RE: **HOLIDAY BREEZE SUBDIVISION (F-22/D36)**
Engineers Certification- (additional detail sheets submitted)
Engineers Stamp dated 10/29/1998, Rev. 1/25/1999, 4/21/1999, 6/26/2002
Engineers Certification dated 3/21/2002

Based upon the information provided in your Engineers Certification dated 3/21/2002, and the subsequent sheets submitted 6/26/2002 providing details of the drainage structure at the end of the new cul-de-sac, and the removal of the proposed bollards and insertion of the new retaining wall, the above referenced plan is adequate to satisfy the Grading and Drainage Certification for the above referenced project.

RE: **HOLIDAY BREEZE SUBDIVISION (F-22/D36)**
Engineers Certification For Release of Financial Guaranty
Engineers Stamp dated 10/29/1998, Rev. 1/25/1999, Rev. 4/21/1999
Engineers Certification dated 3/21/2002

**Re: Holiday Breeze Subdivision Amended Grading Plan
Engineer's Stamp dated 4-20-01 (F22/D36)**

CITY OF ALBUQUERQUE PUBLIC WORKS DEPARTMENT ENGINEERING DEVELOPMENT GROUP			
TITLE: HOLIDAY BREEZE SUBDIVISION OVERALL UTILITY AND PAVING PLAN			
Design Review Committee	City Engineer Approval	Last Design Update	Hydrology
City Project No.	Zone Map No.	Sheet	Of
622481	F-22	4	8

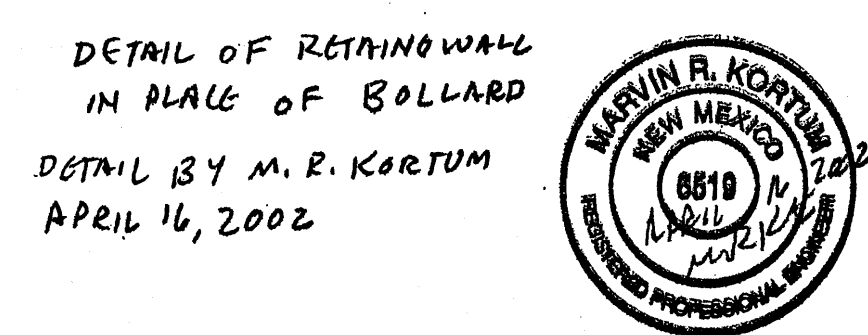
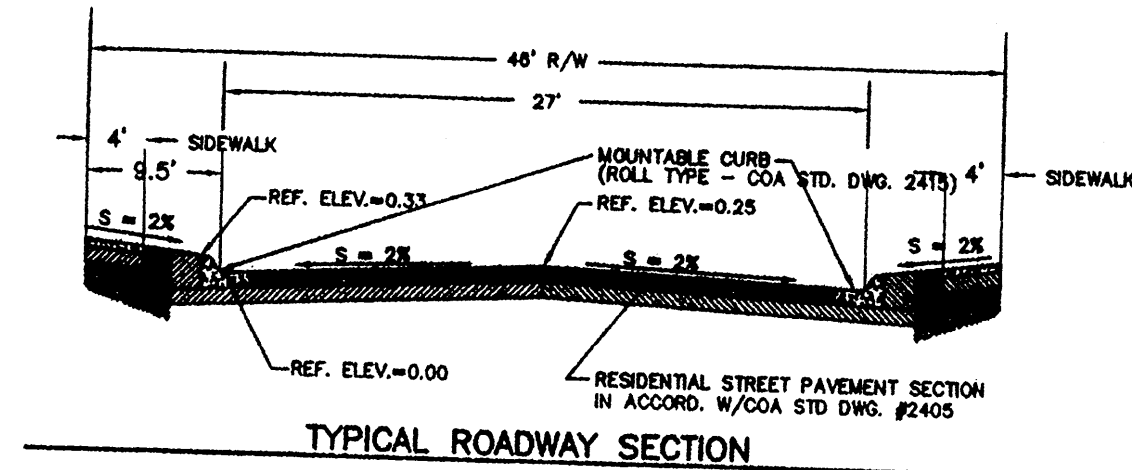
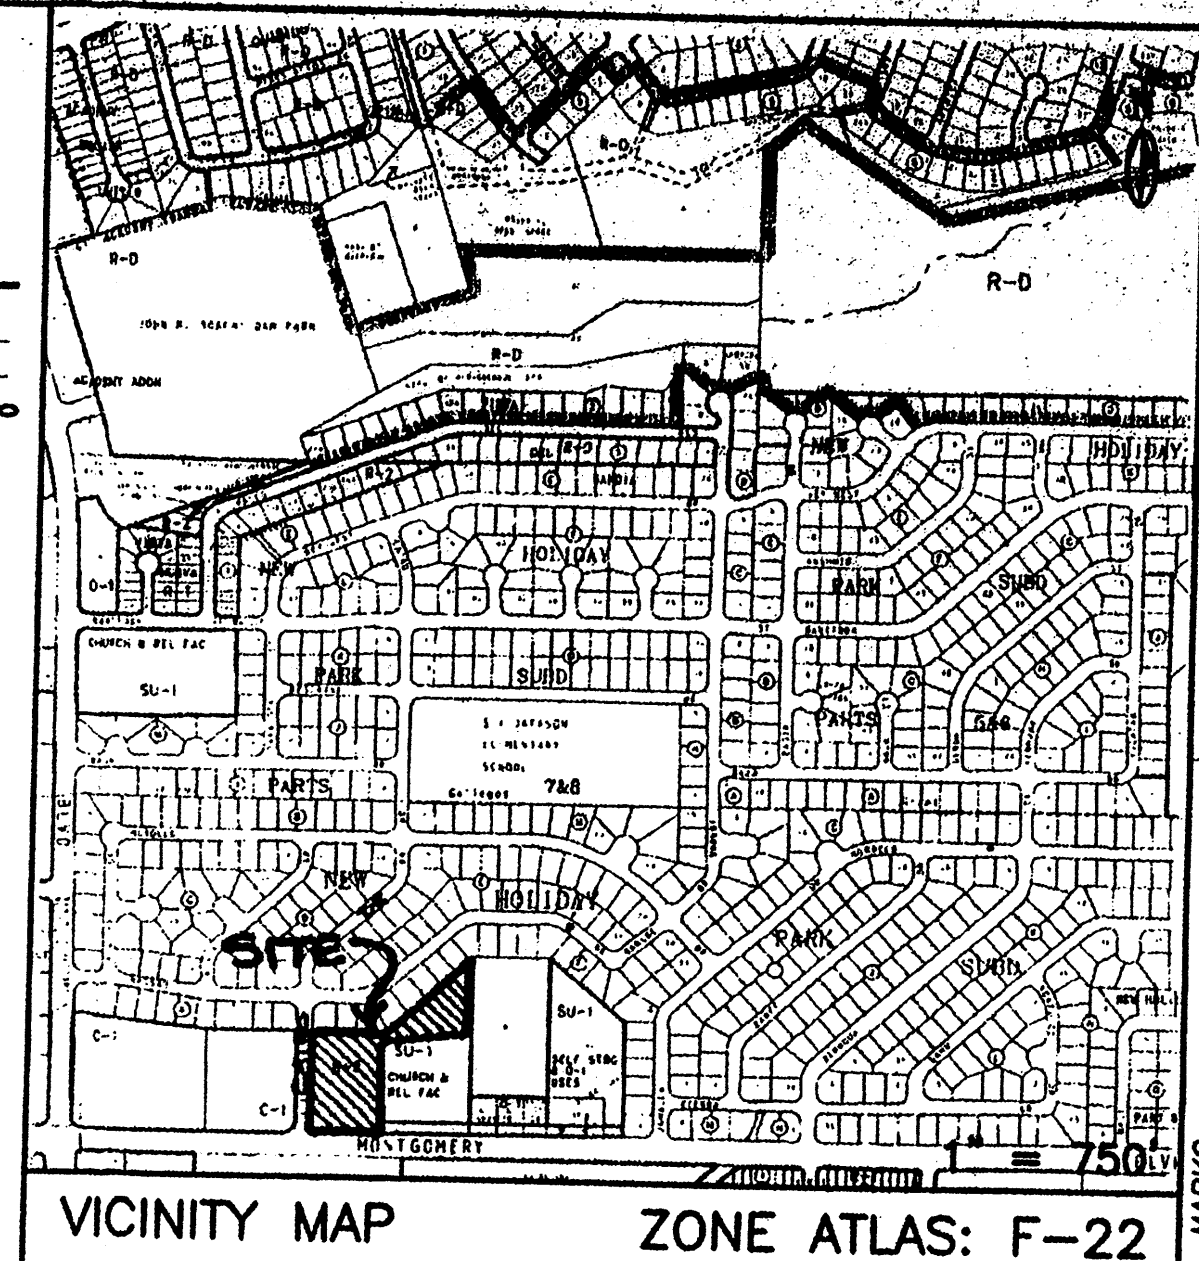
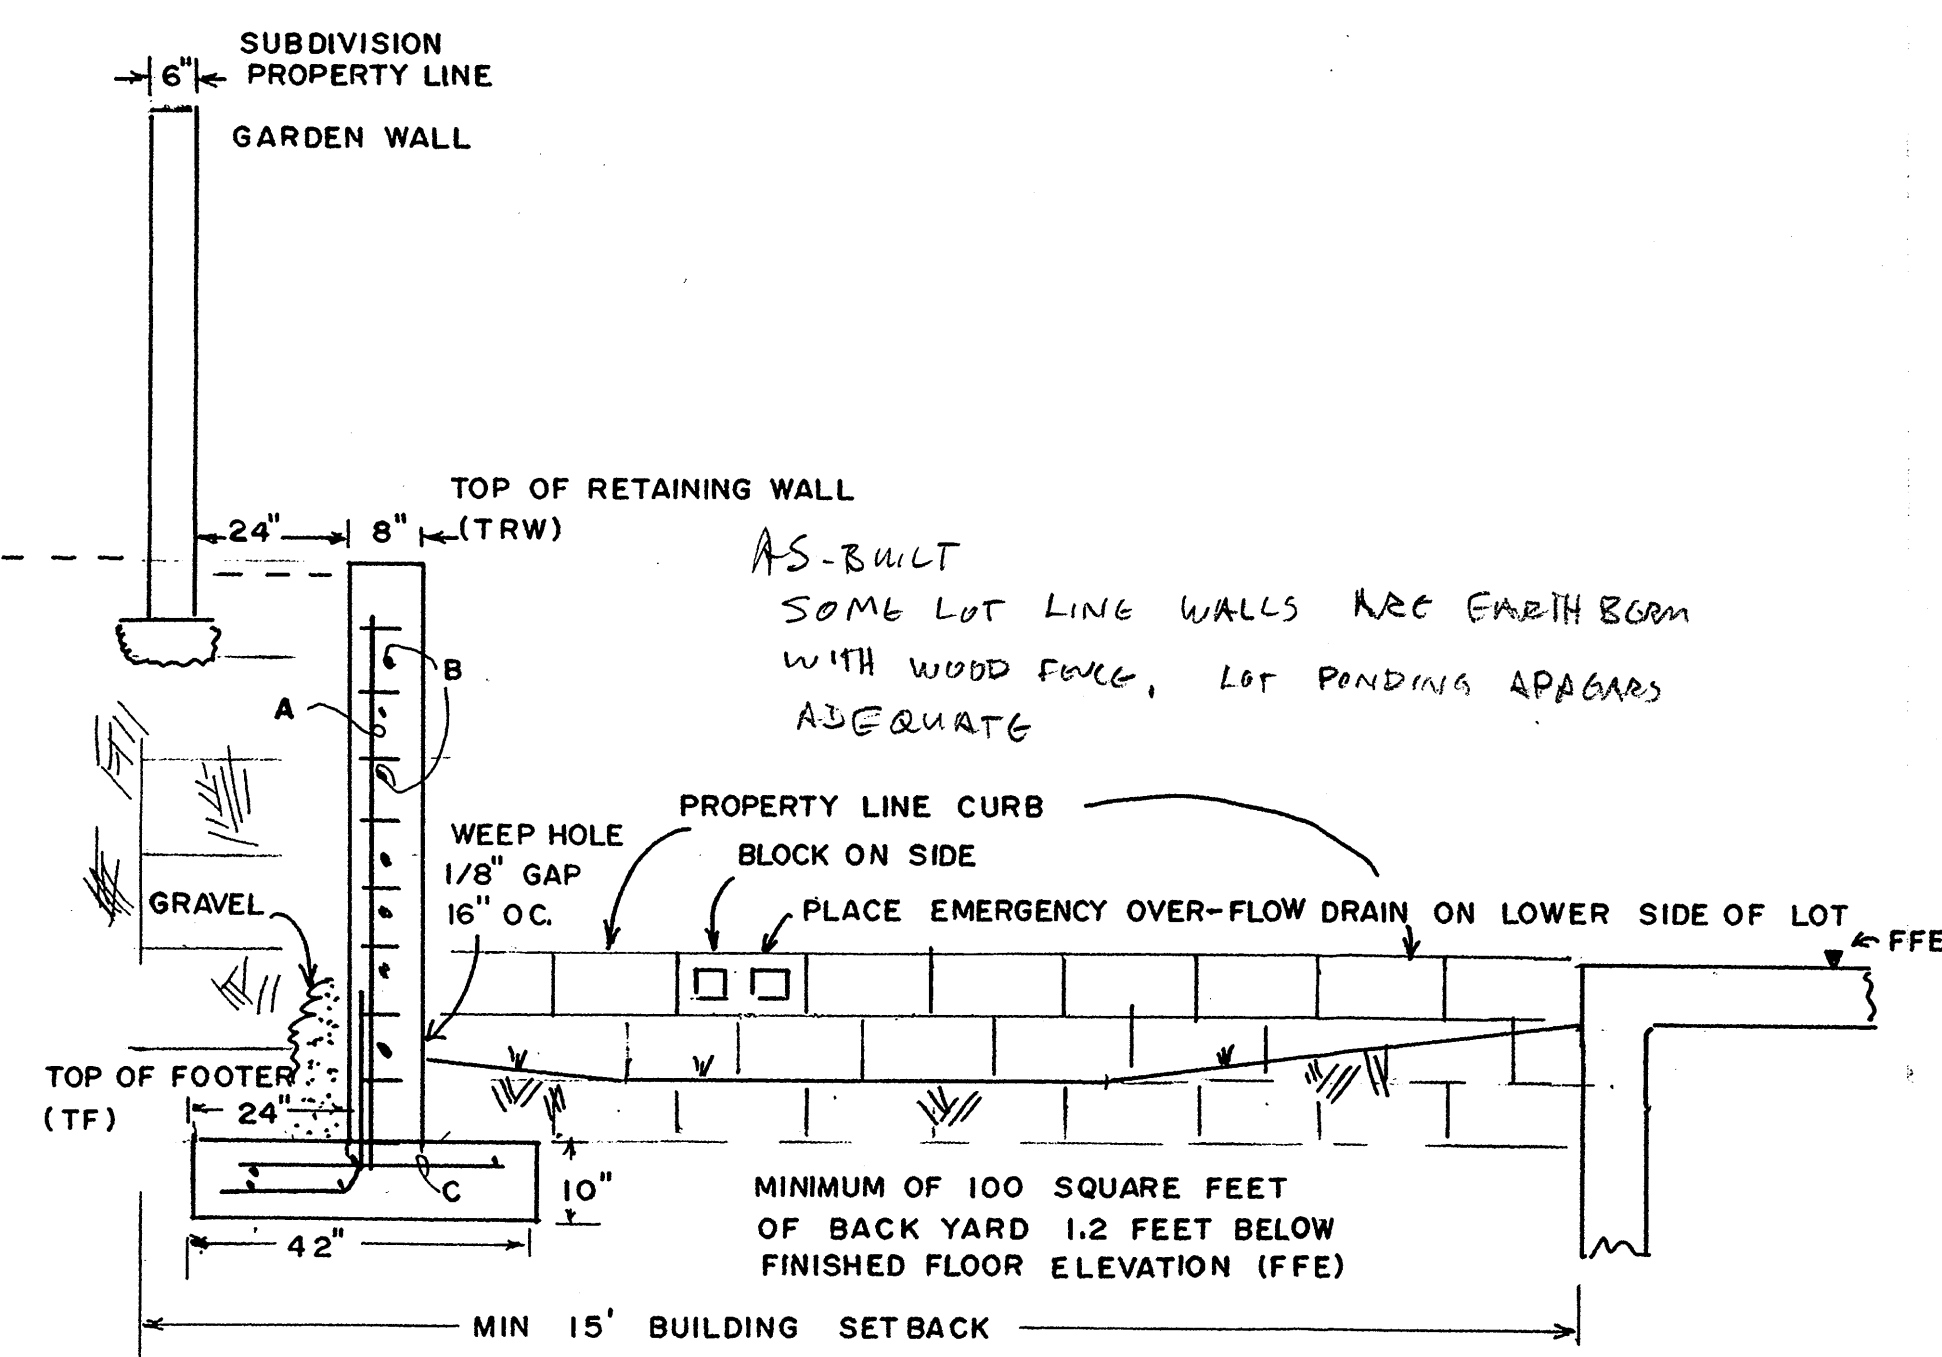
B. The original drawings, sheet 4 of 8, shows 10 bollards placed at 8'-10' intervals along the north side of the street, placed at the back of the curb. These bollards have not been placed. The bollards on the west end of the line were deleted in order to provide vehicle access to lot 1. East of the east corner of lot 1, a retaining wall has been placed away from the curb line, along the existing garden wall of the property to the north. This retaining wall was placed to support the existing wall because of the approximate three feet difference in elevation between the property to the north, and the top of curb elevation to the south. The cluster mail boxes have also been

placed in this location, protected by the new retaining wall. This change to the grading plan provides better protection and support for the adjacent property to the north than the original design with bollards.

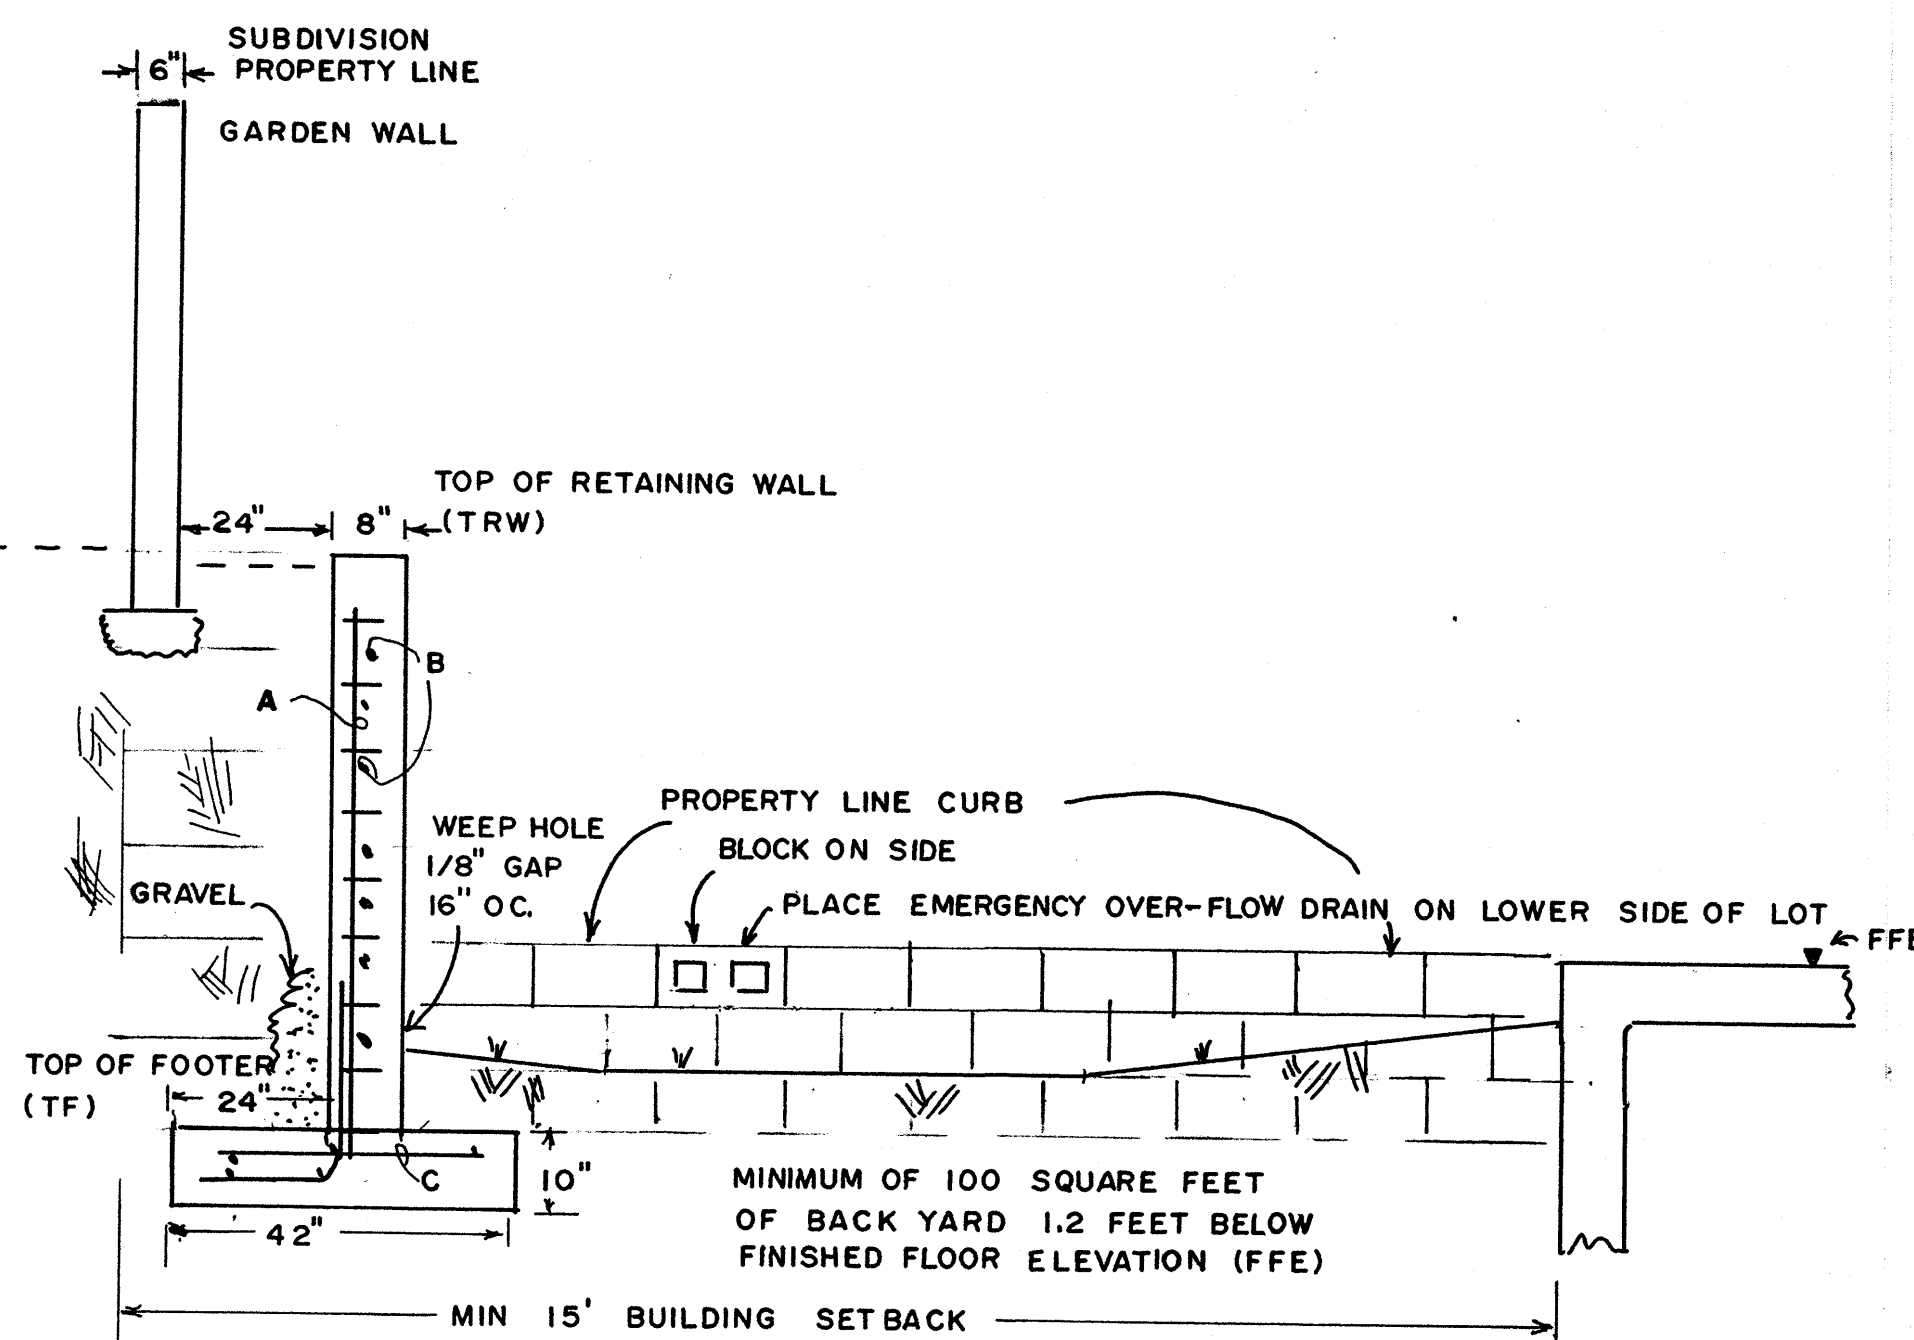
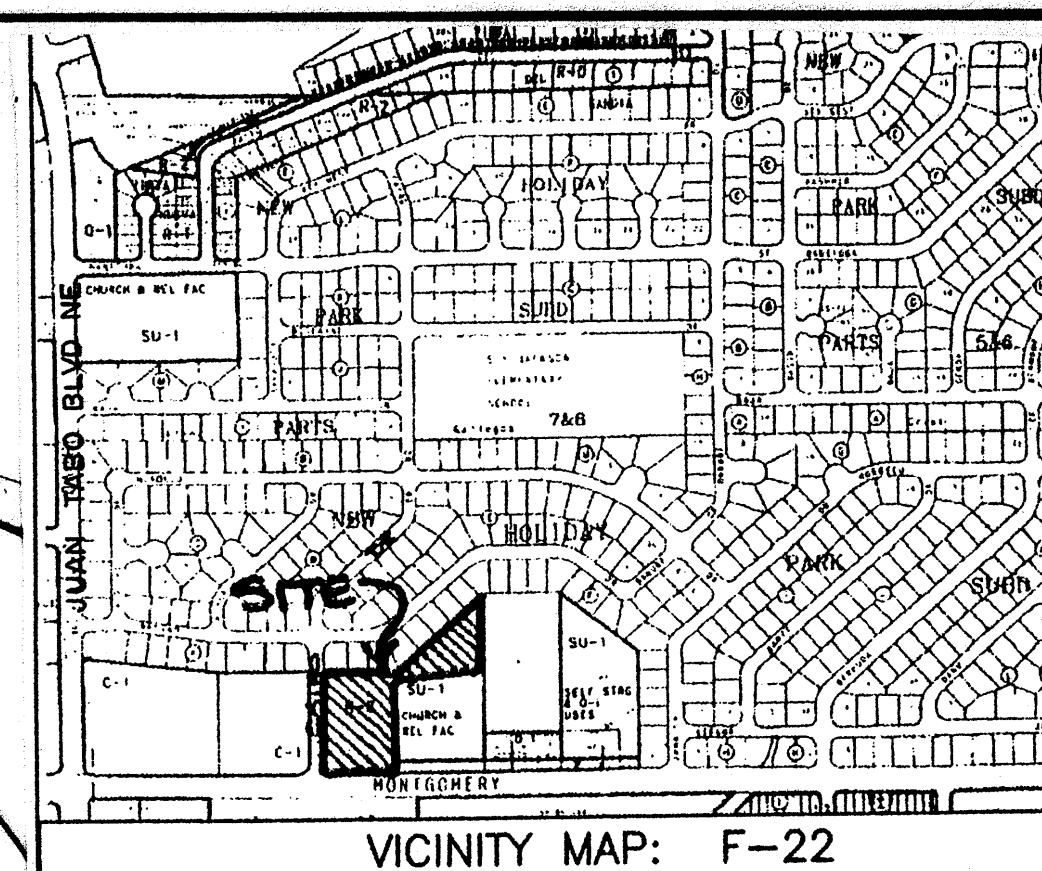
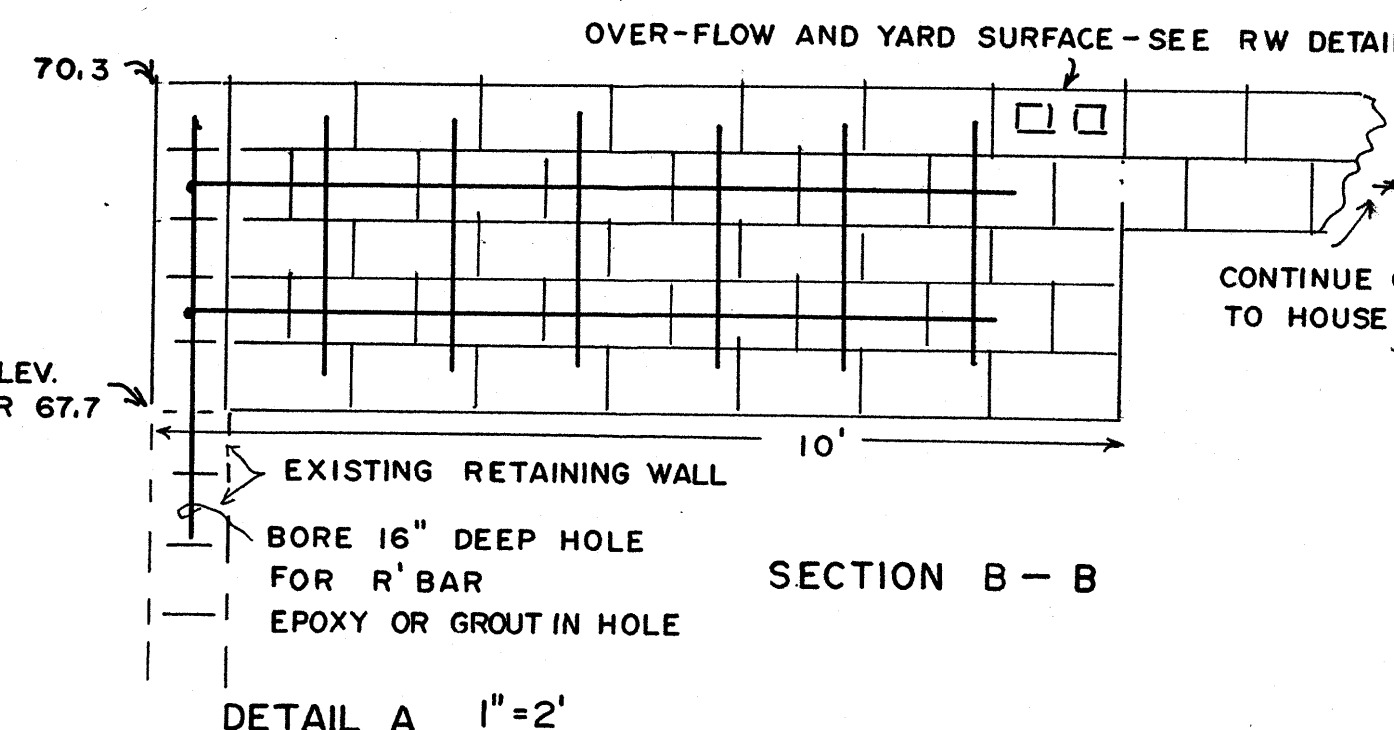
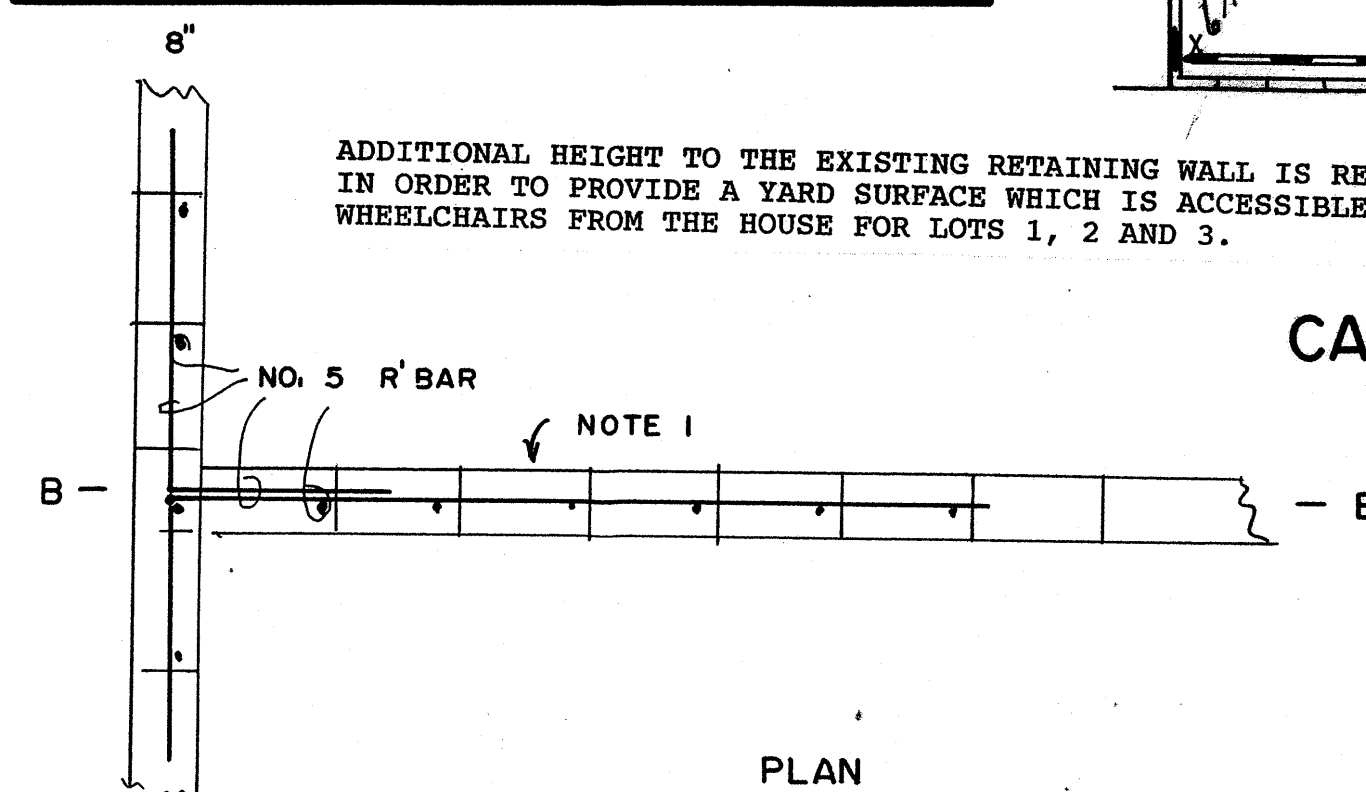
The specific changes required for lots 16 through 30 are that a
retaining wall is required along the east property line so that there
is sufficient area within the back yards for the required ponding, and
also permit the yard surface to be sloped away from the building
perimeter as required by the building code.

The specific changes for lots 1 through 4 are to raise the
retaining wall along Cairo Drive so that the yards are at an elevation
nearer the house elevation in order to have the yards accessible for
wheelchair use.

Based upon the information provided in your submittal dated 4-23-01, the above referenced amended plan is approved for Building Permit and for Grading Permit. These changes are minor enough to forego the need for application to DRB. The original plan dated 4-21-99 and this one will need to be certified to release Financial Guarantees. Building Permit.
